fao Mr G Northern
Case Officer
your ref 2014/0607
our ref JBA.3330
11th August 2014

PROPOSALS @ 2 MELLWOOD GROVE HEMMINGFIELD

- JBA.3330.sk.1 revised front and side elevation,
- JBA.3330.sk.2 revised ground and first floor layouts relating to the above elevations.

12.8.14  
JBA.3330.SK 1

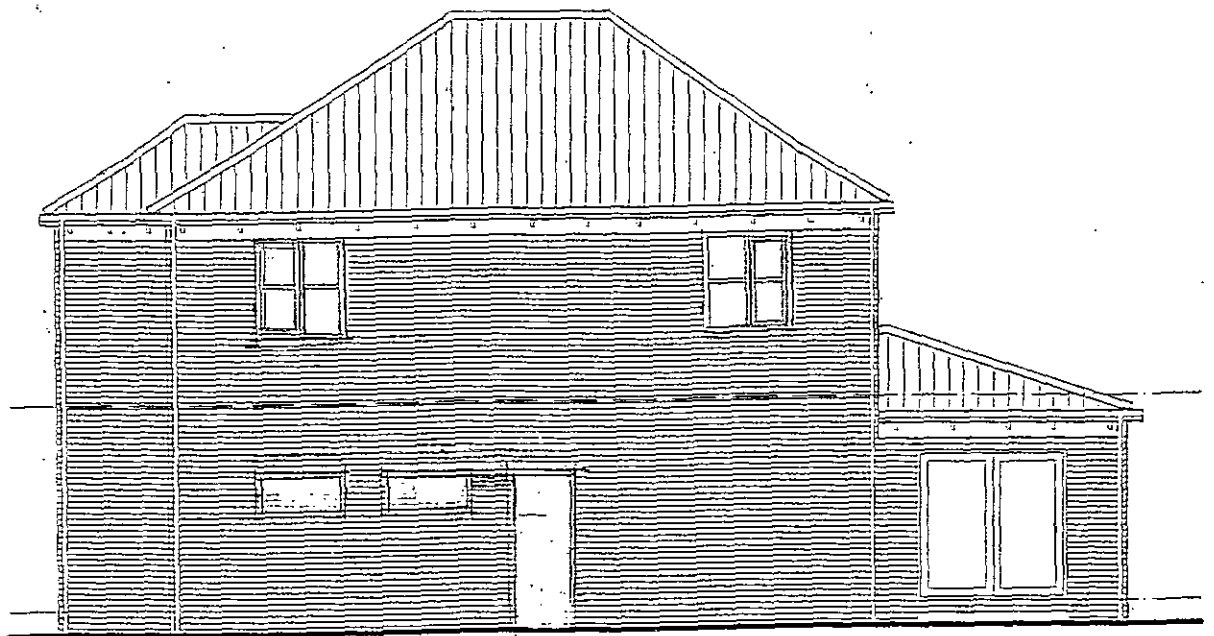
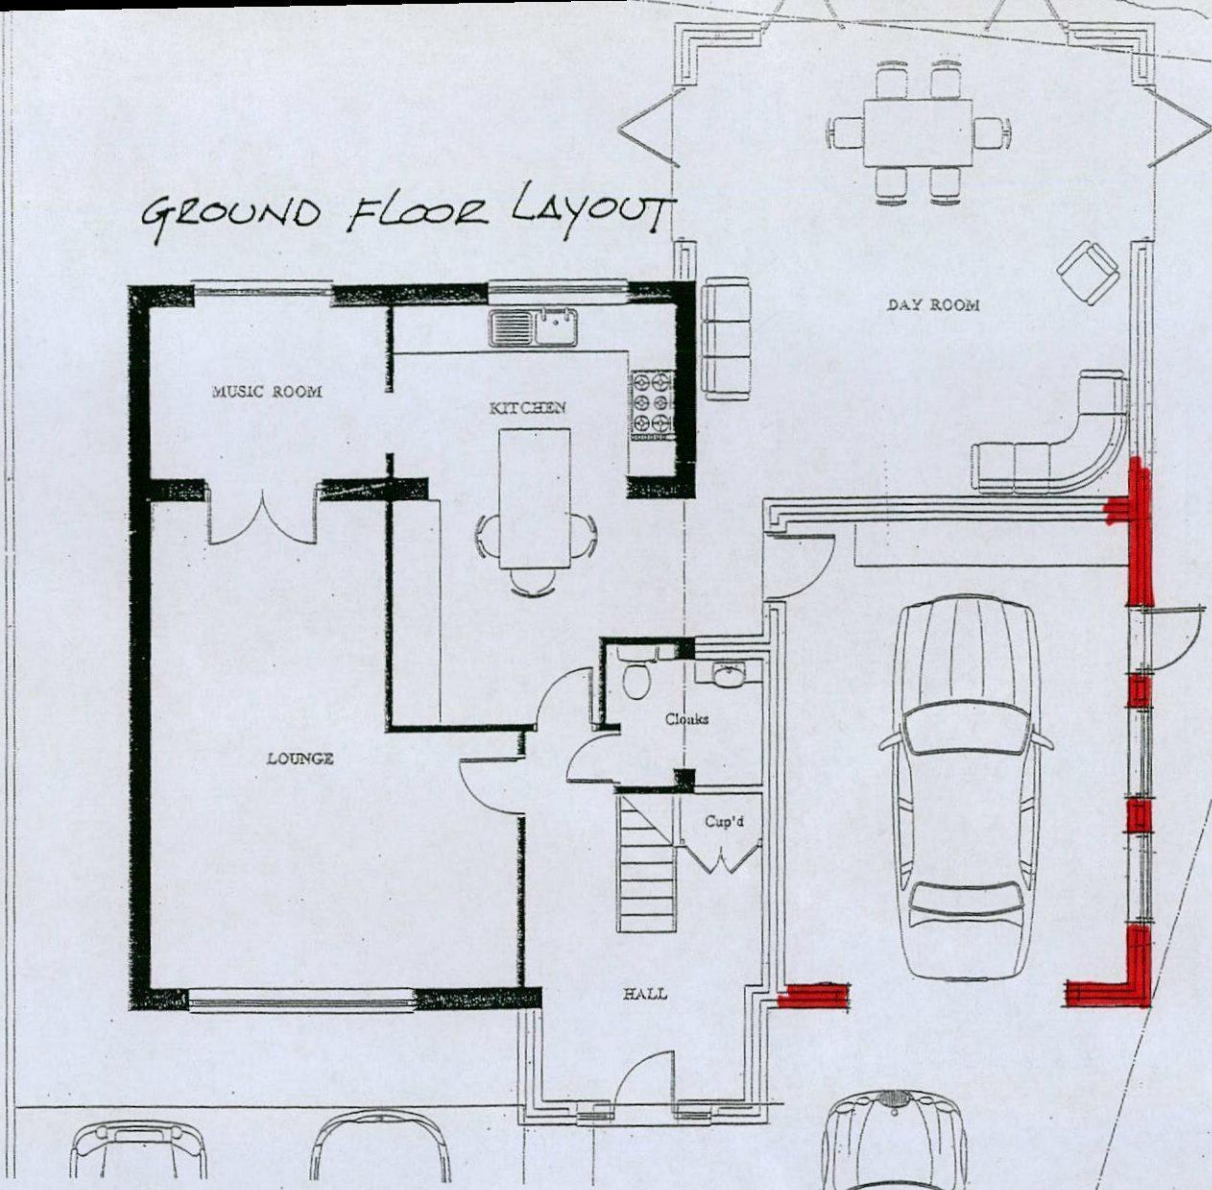
Taking the first sketch referred to above it will be noted that the front elevation now gives, in architectural terms, a prime example of duality and the two level protruding hall and part study above sits directly central and "breaks" the horizontal effect of the front elevation. So far as the side elevation is concerned, to lessen the masonry impact to the road scene, we have introduced at ground floor level, a service door to the garage, positioned centrally, and a high level window to its left. Then at first floor level we have positioned a further window to the master bedroom and balanced that with a widow in the en-suite that replaces the window to the rear elevation. This will mean that the orientation of the en-suite will need to be revisited.
